FROM: Katie Kurek

SUBJECT: BE/180/16/PL - 1 No. dwelling. This application affects the setting of a Listed Building. More Information. Revised drawings and responses.

Land adj to 2, North Bersted Street, Bognor Regis, West Sussex, PO22 9AD

Date	Feb 2017	Drawn by	scb
Scales	@ A1	Status	PLANNING
Job No	TSP 573	Dwg No	PL-10
		Revision	B

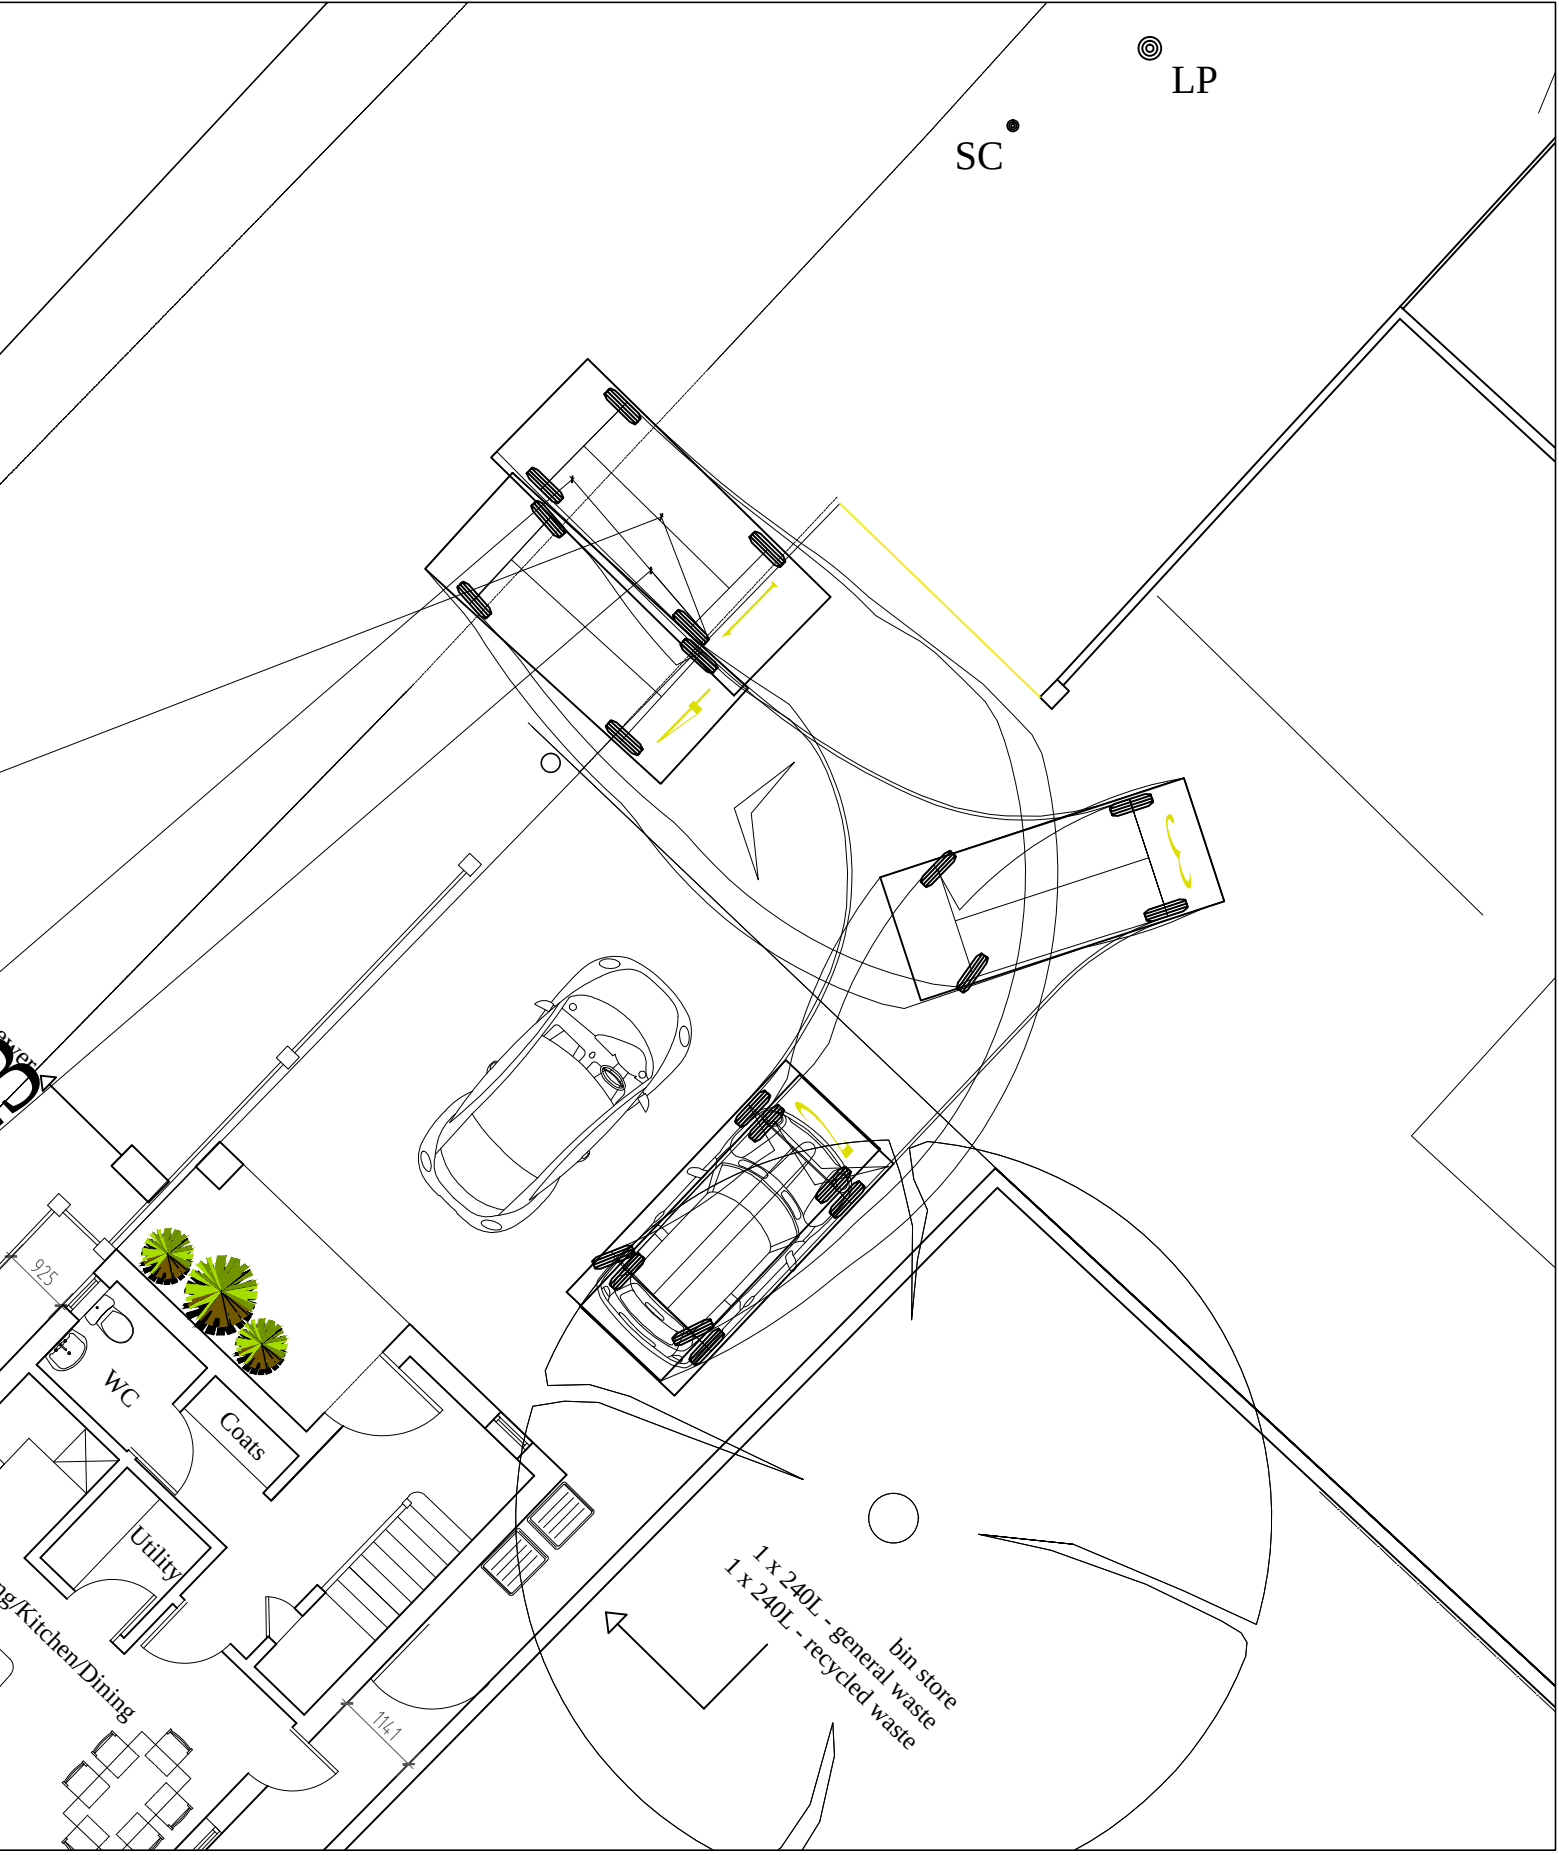
Amended plan PL-10 B demonstrates car swept path for the new dwelling showing that a car can park, manoeuvre on site and exit on to the public highway in a forward gear. The LHA are satisfied with the parking and turning arrangements for the new dwelling.

The architect has also clarified that the existing car parking will be in garage and on concrete driveway adjacent existing dwelling and will not impede on turning area for the new dwelling. No gate or dividing feature is proposed between the properties on the existing frontage. Removal of the splayed wall will improve turning for the existing dwelling. Nevertheless, the existing dwelling is currently operating without a turn on site without evidence of highway safety concern.

The architect has clarified that the set back of the fence will result in a hardbound strip of land between the site and the footway which will be maintained by the applicant. Sight lines indicate that a splay of 24.6 metres to the south nearside carriageway edge is achievable. To a one metre off set from the carriageway edge approximately 31 metres is achievable. Under Manual for Streets guidance this equates to a Stopping Sight Distance of approximately 23 mph. Considering the vicinity to the mini roundabout junction and the improvement over the existing visibility the LHA accept these visibility splays at the existing access point.

No part of the development shall be first occupied until visibility splays of 2.4 metres by 70 metres to the north and 2.4 metres by 24.6 metres to the south have been provided at the existing site vehicular access onto North Bersted Street in accordance with the approved planning drawings. Once provided the splays shall thereafter be maintained and kept free of all obstructions over a height of 0.6 metre above adjoining carriageway level or as otherwise agreed.

No part of the development shall be first occupied until the vehicle parking and turning spaces have been constructed in accordance with the approved plan. These spaces shall thereafter be retained for their designated use.
